CHRIS TEAM SUBDIVISION

FINAL DRAINAGE REPORT

EL PASO COUNTY PROJECT NO: SF246

ALL TERRAIN ENGINEERING PROJECT NO: 24019

EXISTING CONDITIONS DRAINAGE MAP

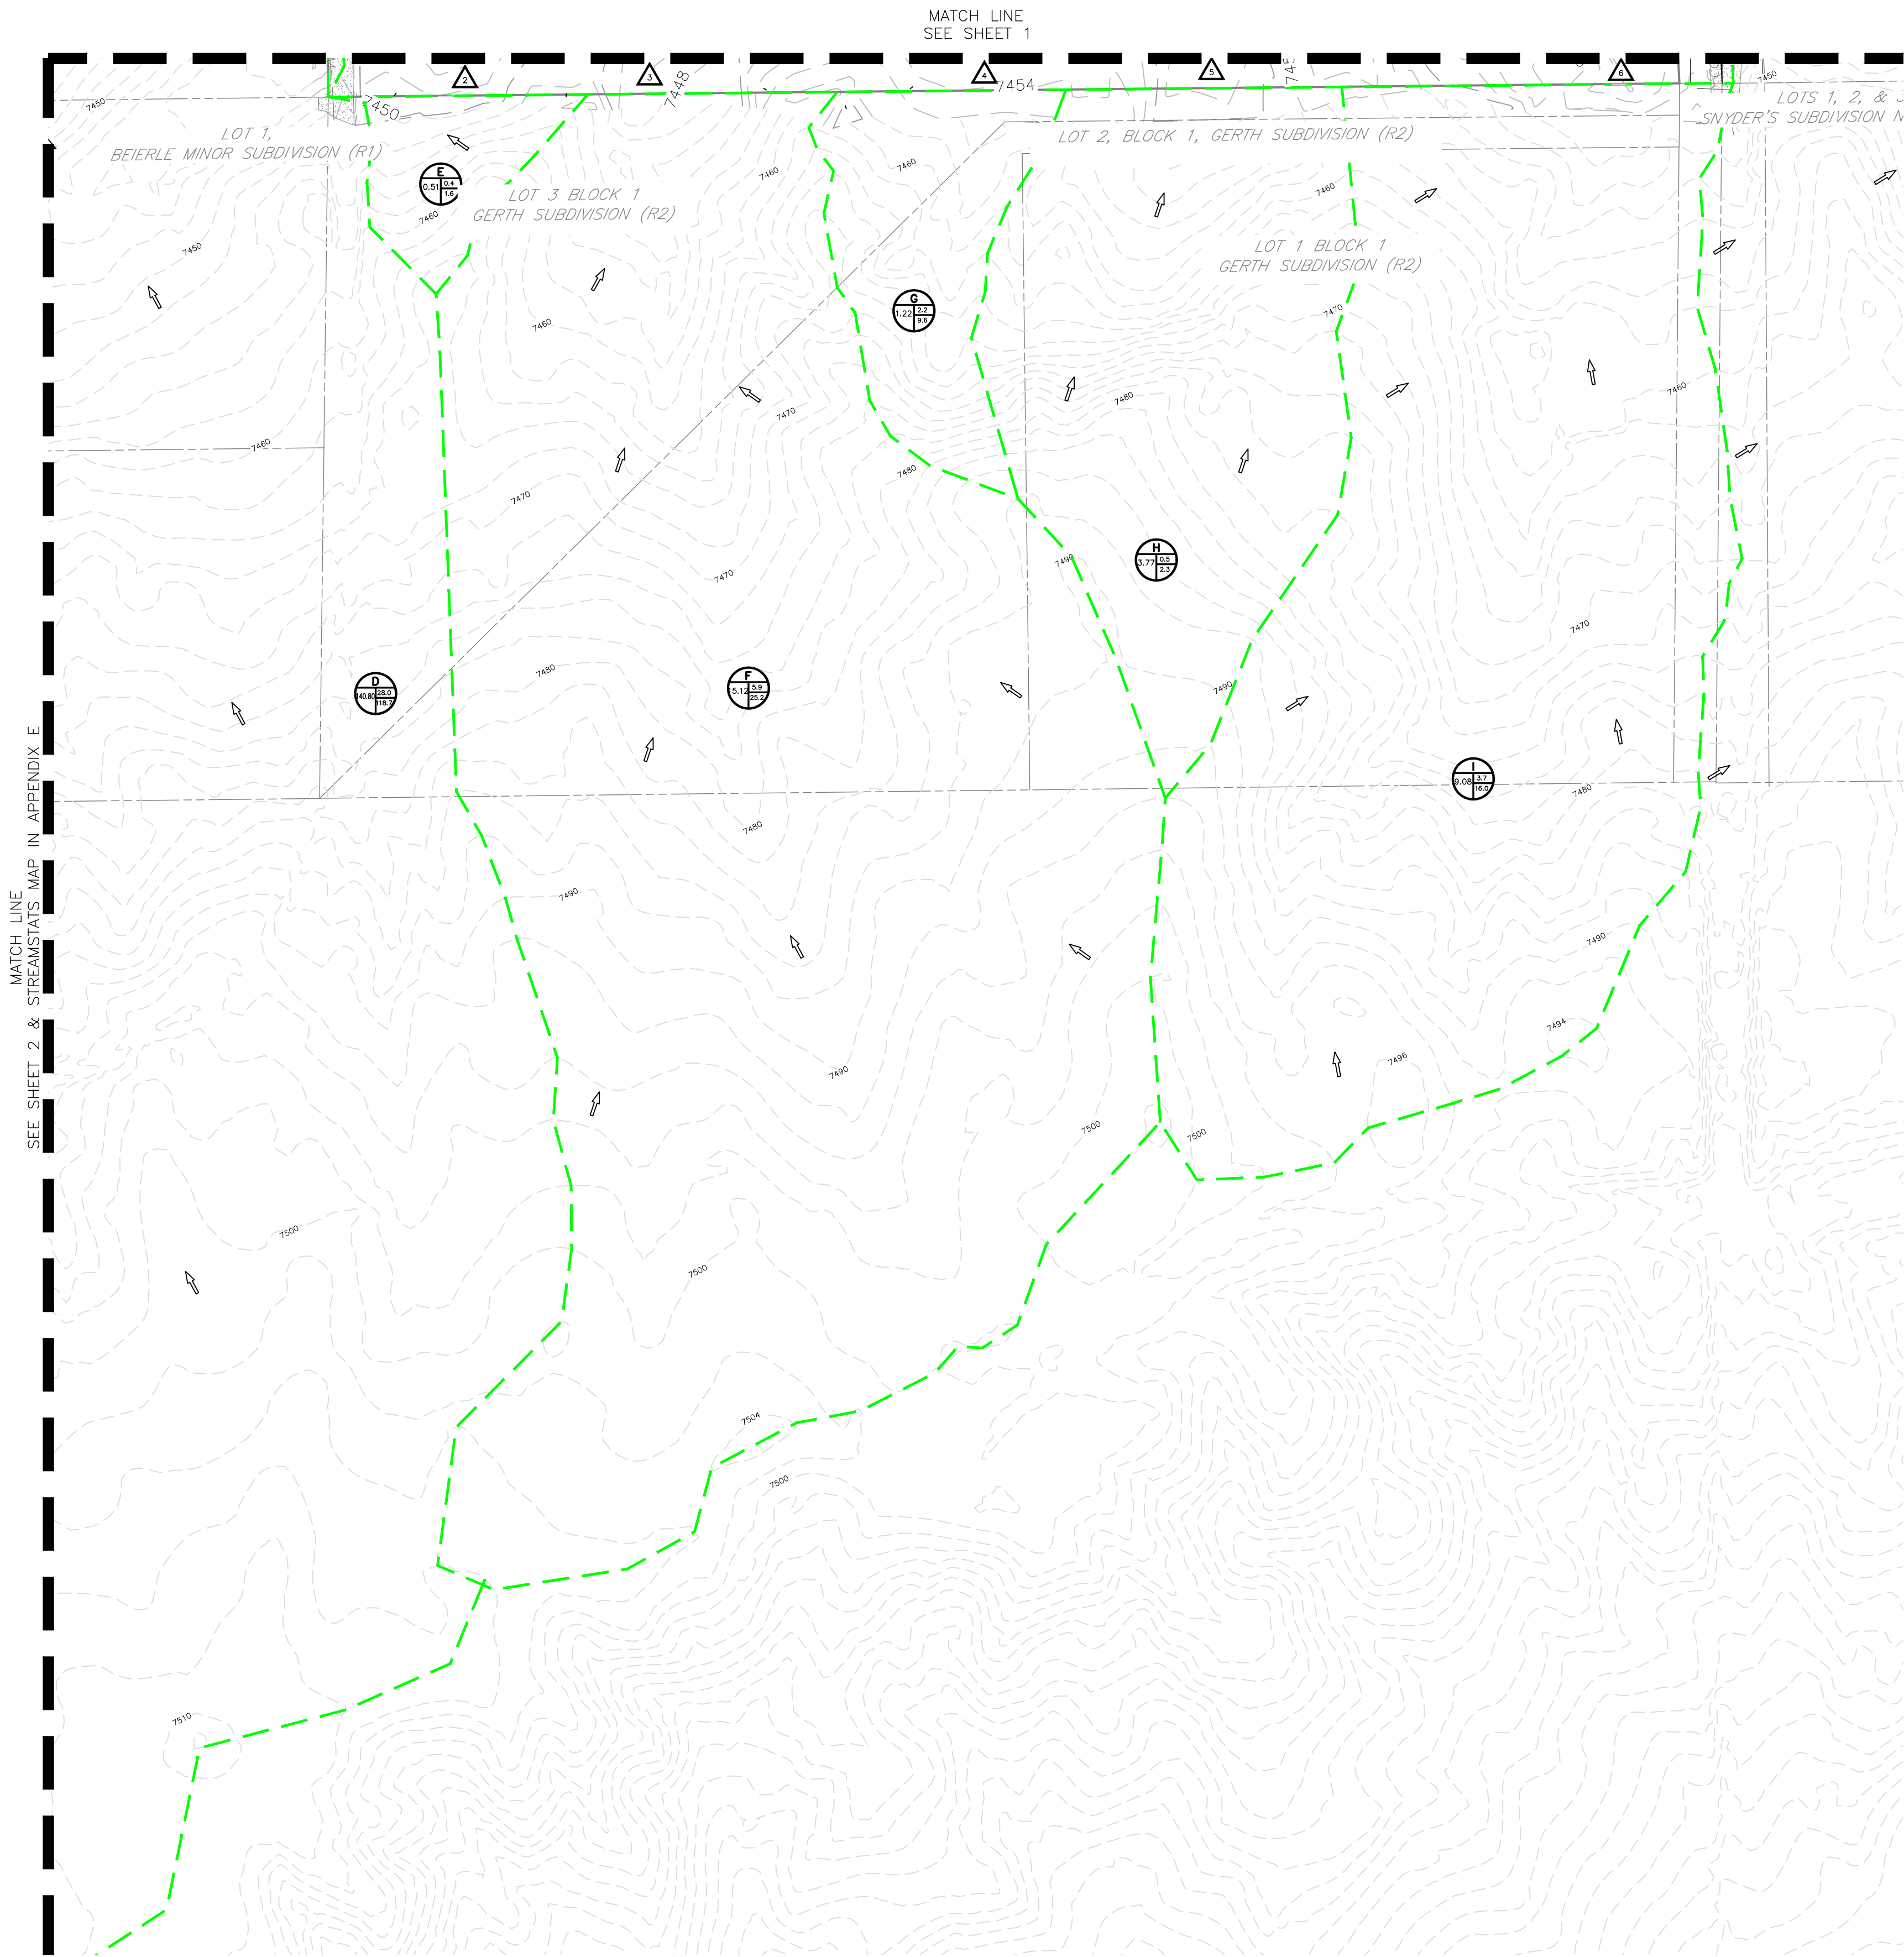
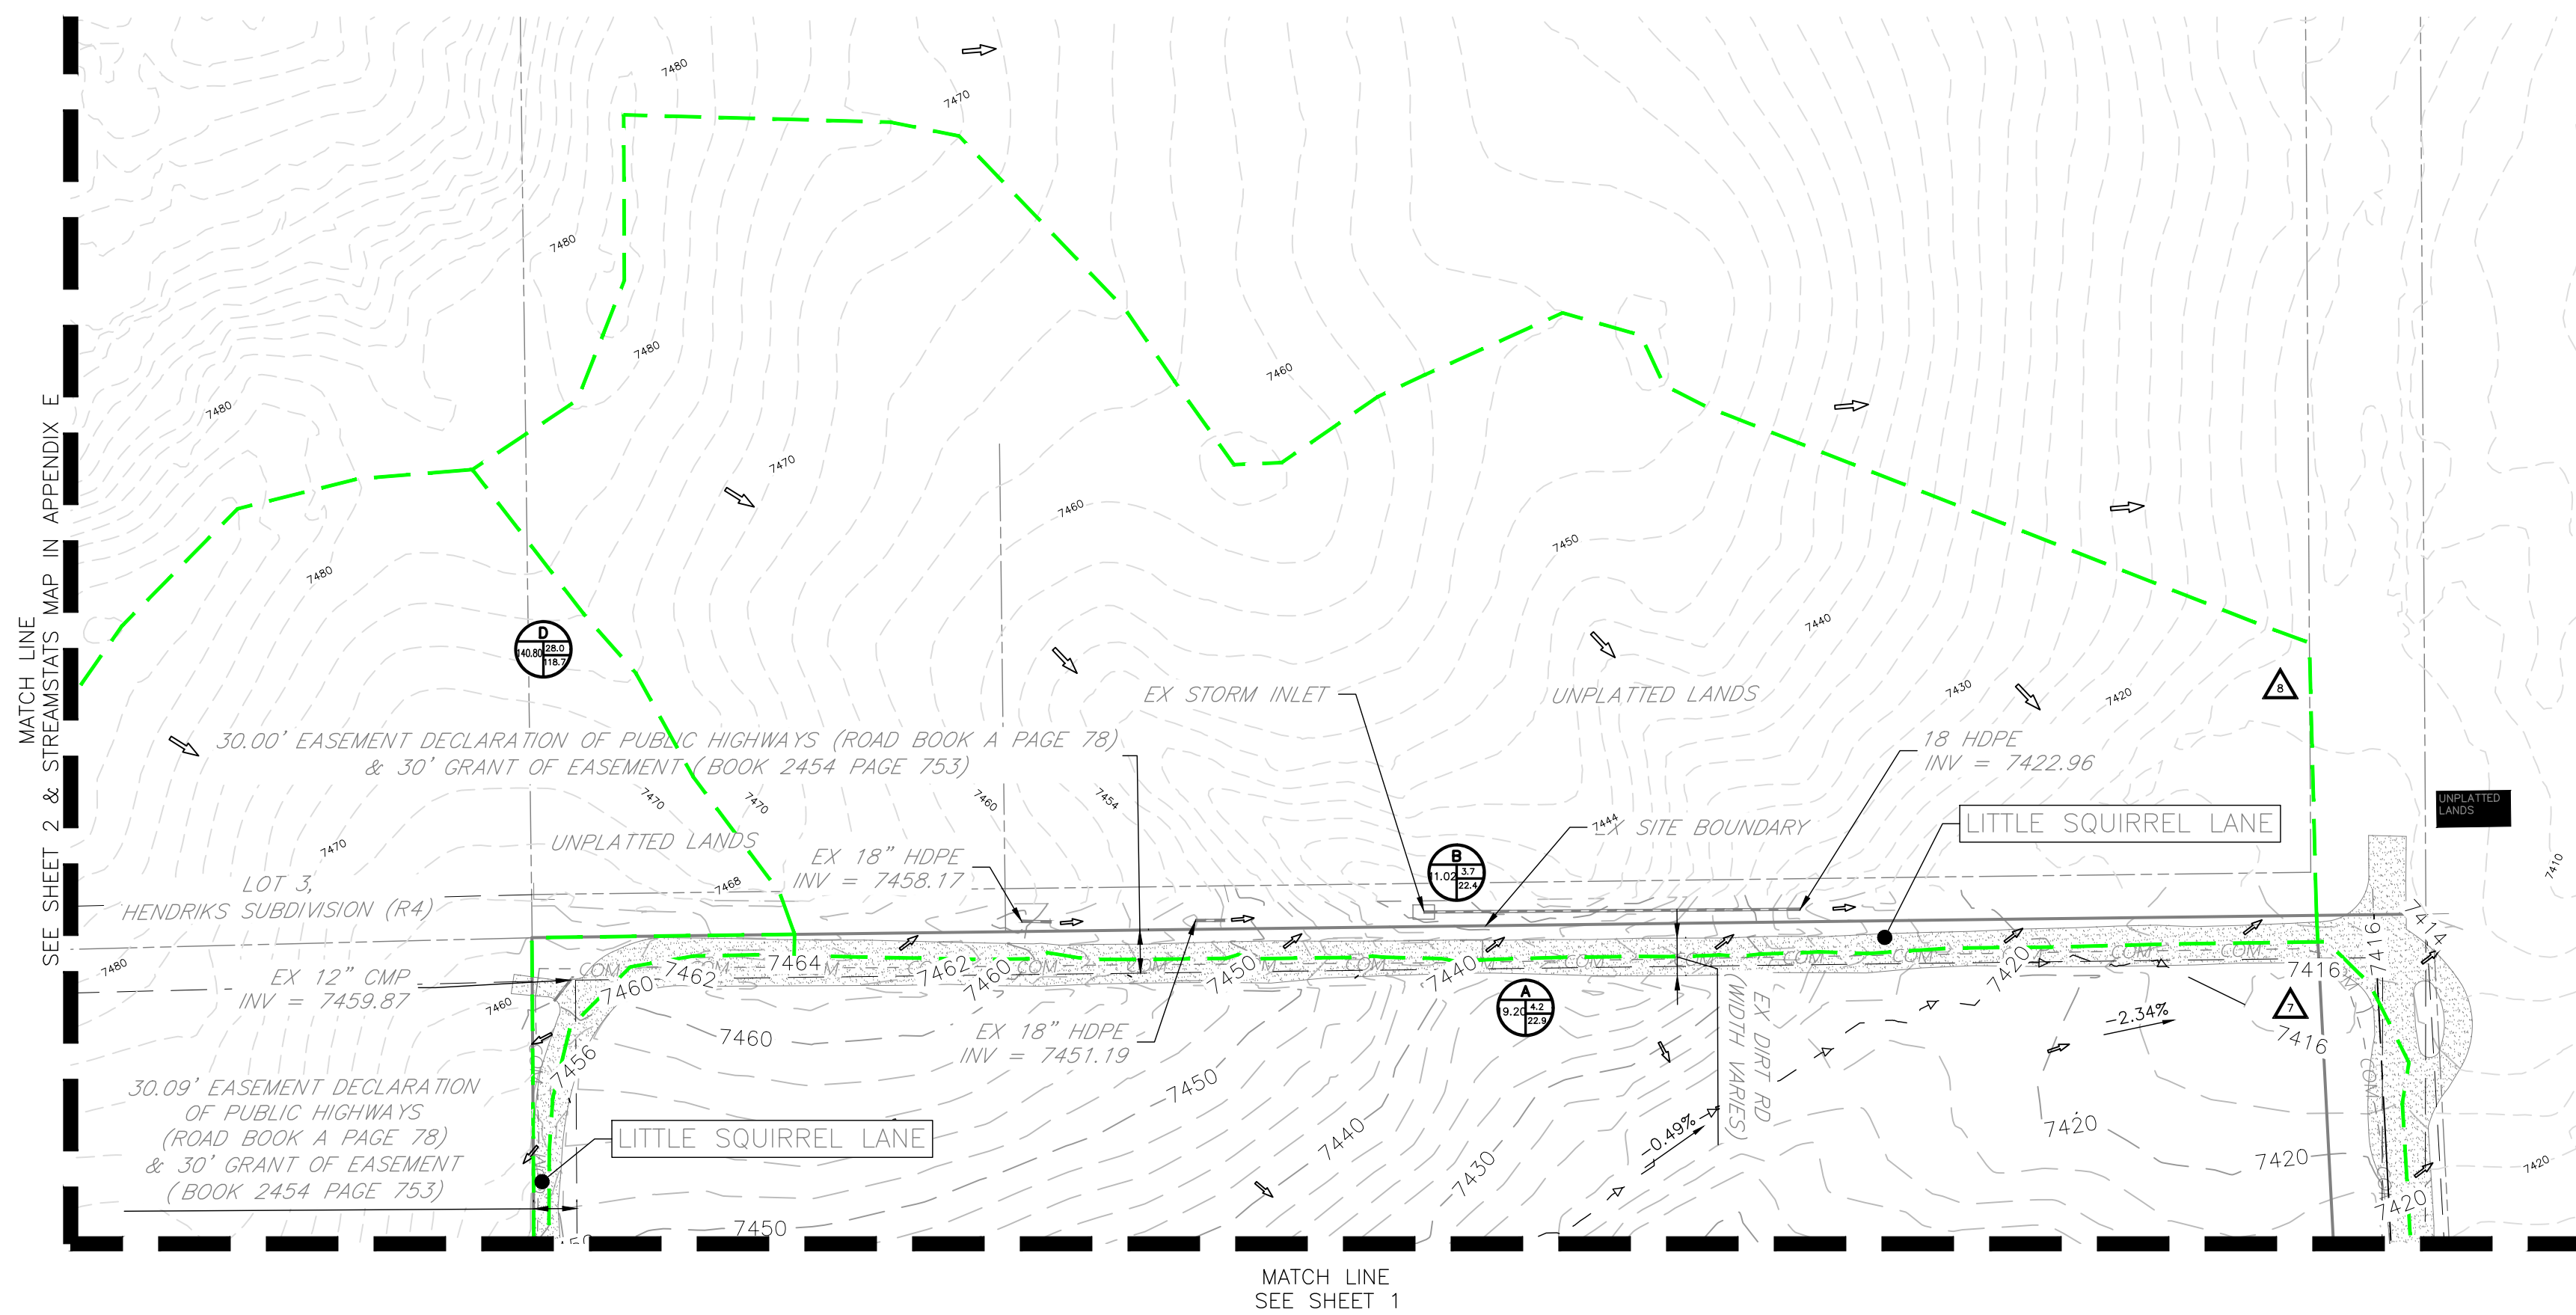
Looks like this is DP7 now. Based on flow arrows, it looks like a portion of the roadways flow offsite and not onsite

Review 1 unresolved comment: Include a discussion of the existing 12" culvert at the NW corner of the site, as shown on drainage map. There is a comment on the map to identify the culvert of interest.

What is overtopping depth/width/velocity? Does it meet overtopping criteria per DCM table 6-4?

Previous report stated there was a roadside ditch along road, directing flows to culvert. This was deleted, so how are flows being directed to low point? Also provide discussion of existing culvert at NW corner of site in Basin C.

Expand discussion on culvert overtopping. What is depth/width/velocity? Does it meet EPC criteria in DCM section 6.4?

PROPOSED CONDITIONS DRAINAGE MAP

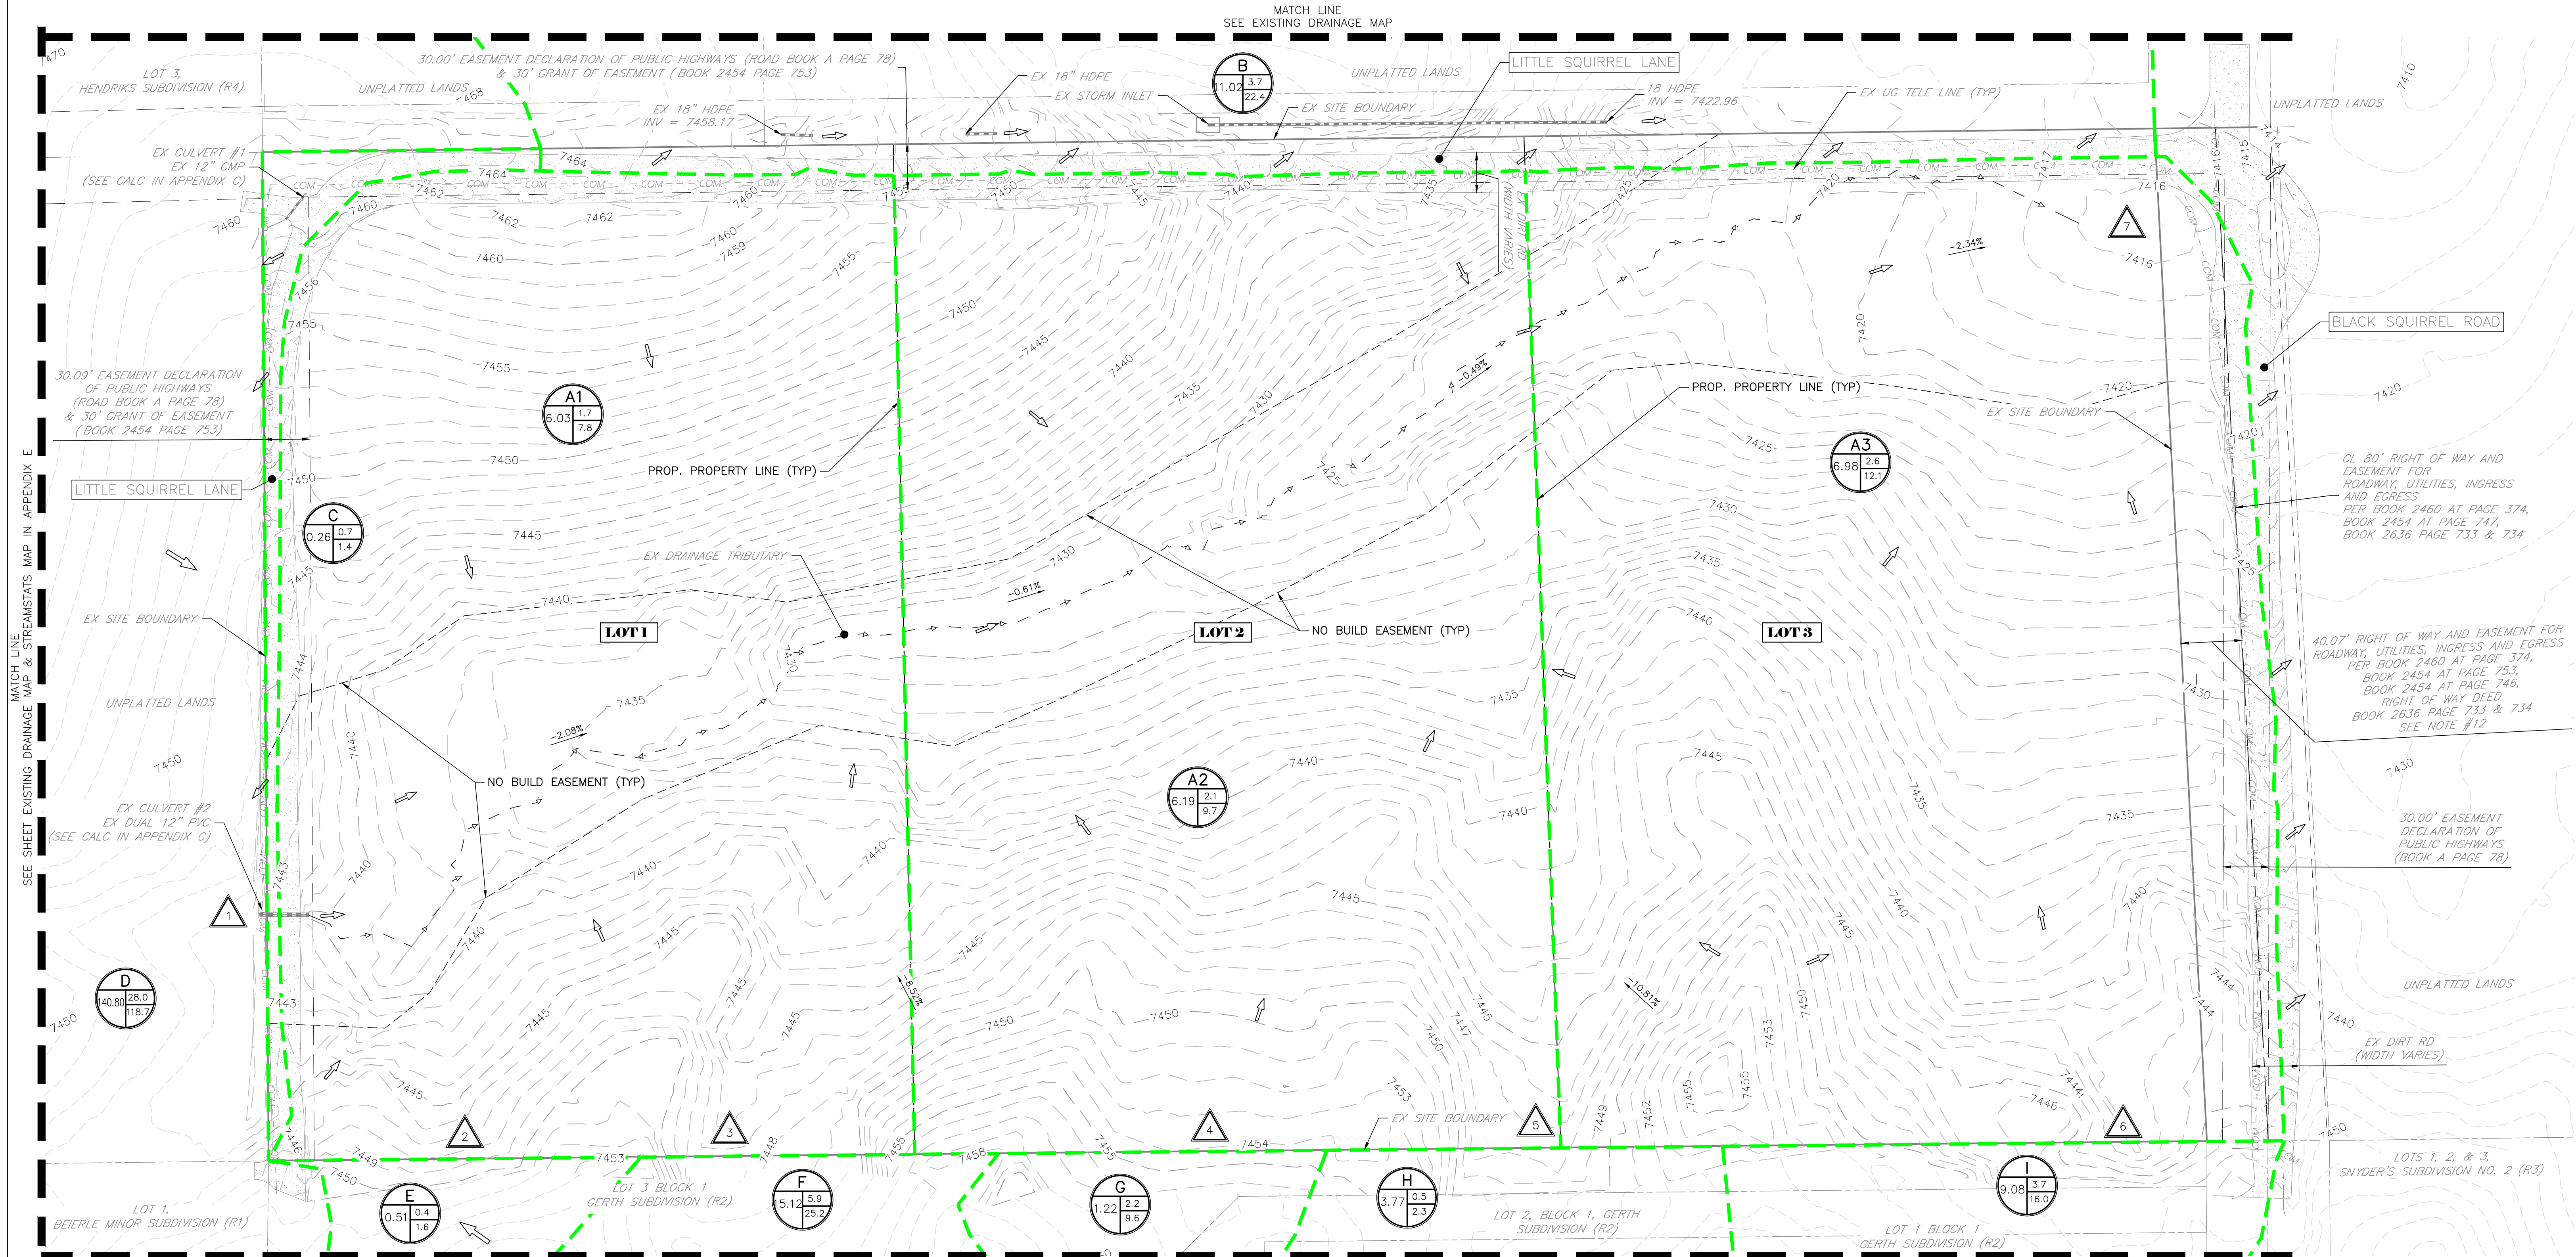
Please provide minimum driveway culvert sizing for driveways. You can do just one worse case scenario and then add caveat that sizes will be finalized with lot specific drainage reports.

Please update this comparison based on drainage map and other comments.

Table should compare flows at DP7, not Basin A
